Consultee Comment for planning application 23/01633/F

Application Number	<input type="text" value="23/01633/F"/>
Location	<input type="text" value="Site at Calthorpe Street and Marlborough Road Banbury"/>
Proposal	<input type="text" value="Demolition of existing retail units and public car park and redevelopment for residential dwellings (C3 Use), provision of private car parking, hard and soft landscaping and photovoltaic (PV) panels on roof, and associated works"/>
Case Officer	<input type="text" value="Chris Wentworth"/>
Organisation	<input type="text" value="Building Control (CDC)"/>
Name	<input type="text"/>
Address	<input type="text" value="Building Control Cherwell District Council Bodicote House White Post Road Bodicote Banbury OX15 4AA"/>
Type of Comment	<input type="text" value="Comment"/>
Type	<input type="text"/>
Comments	<input type="text" value="Full Building Regulations approval should be determined at an early stage due to the complexity of the proposed works.

Client:
Tri7
Project:
Calthorpe Street, Banbury
Drawing Title:
Block A-B Second Floor Plan
Drawing Status:
PLANNING

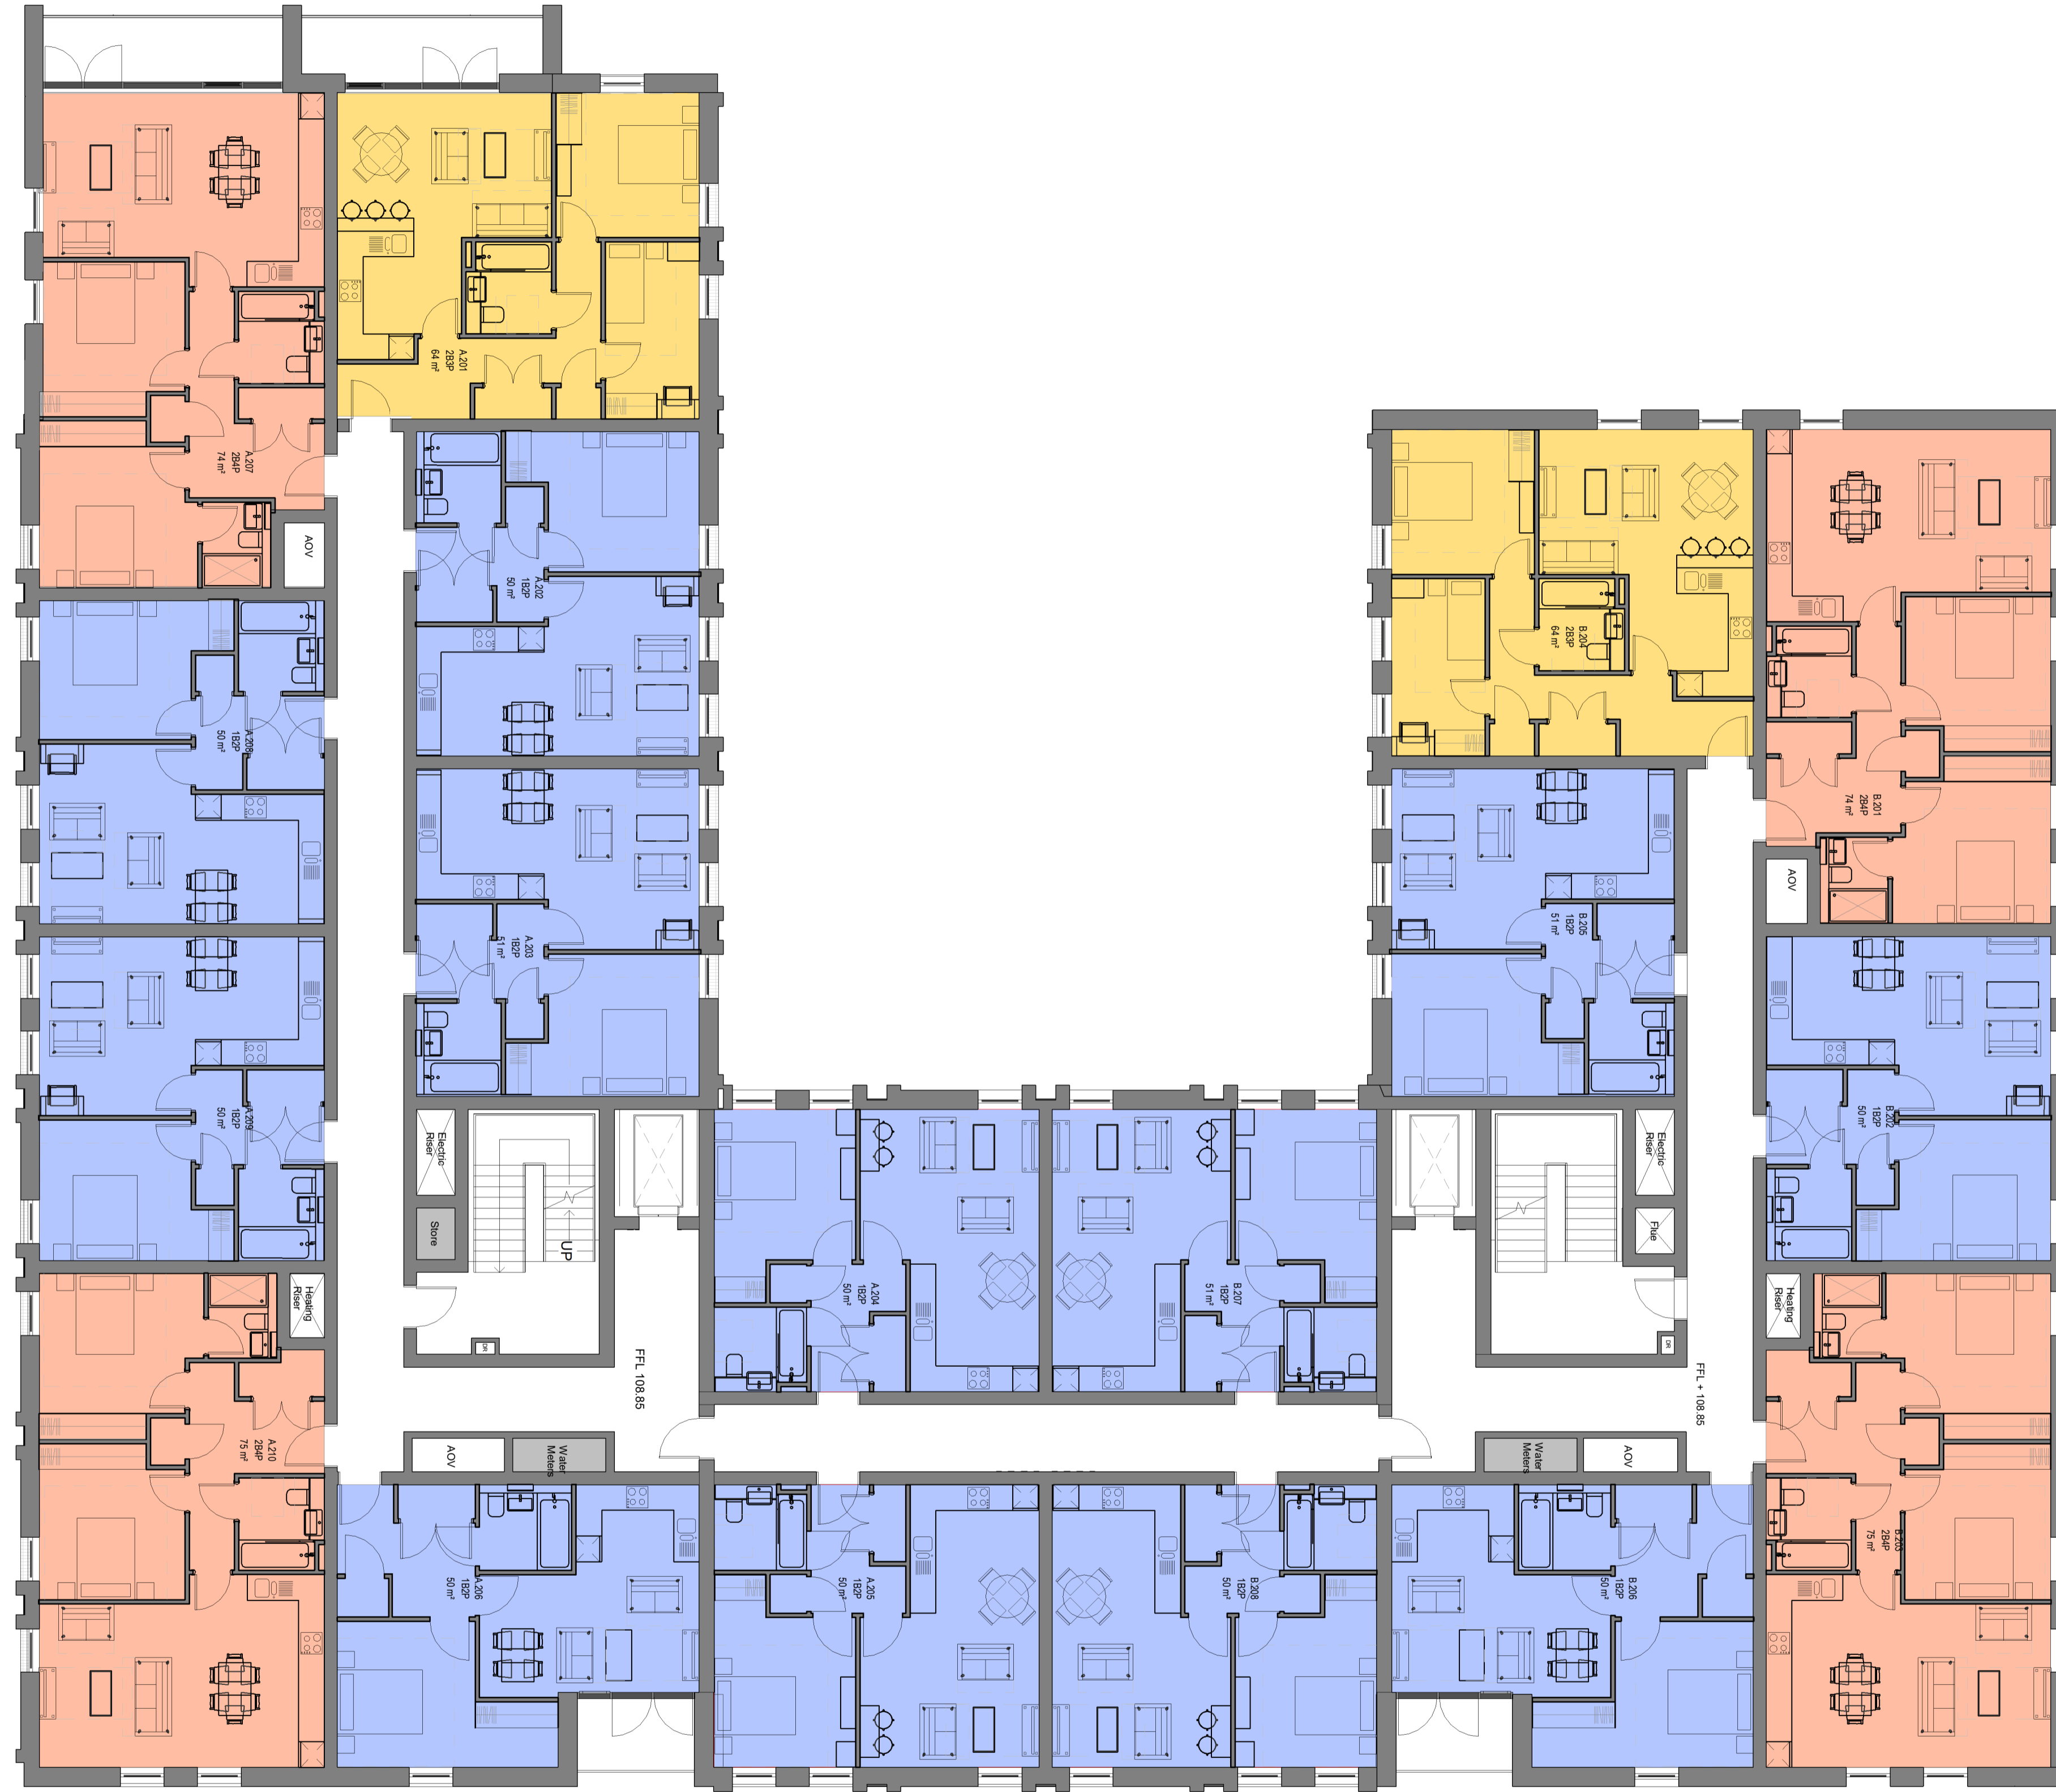
A brief look at the layout plans for the various blocks reveals a number of 'dead-end' conditions where the safe travel distances for fire escape are exceeded, and therefore not compliant from a fire safety point of view."/>
Received Date	<input type="text" value="30/01/2024 10:33:44"/>
Attachments
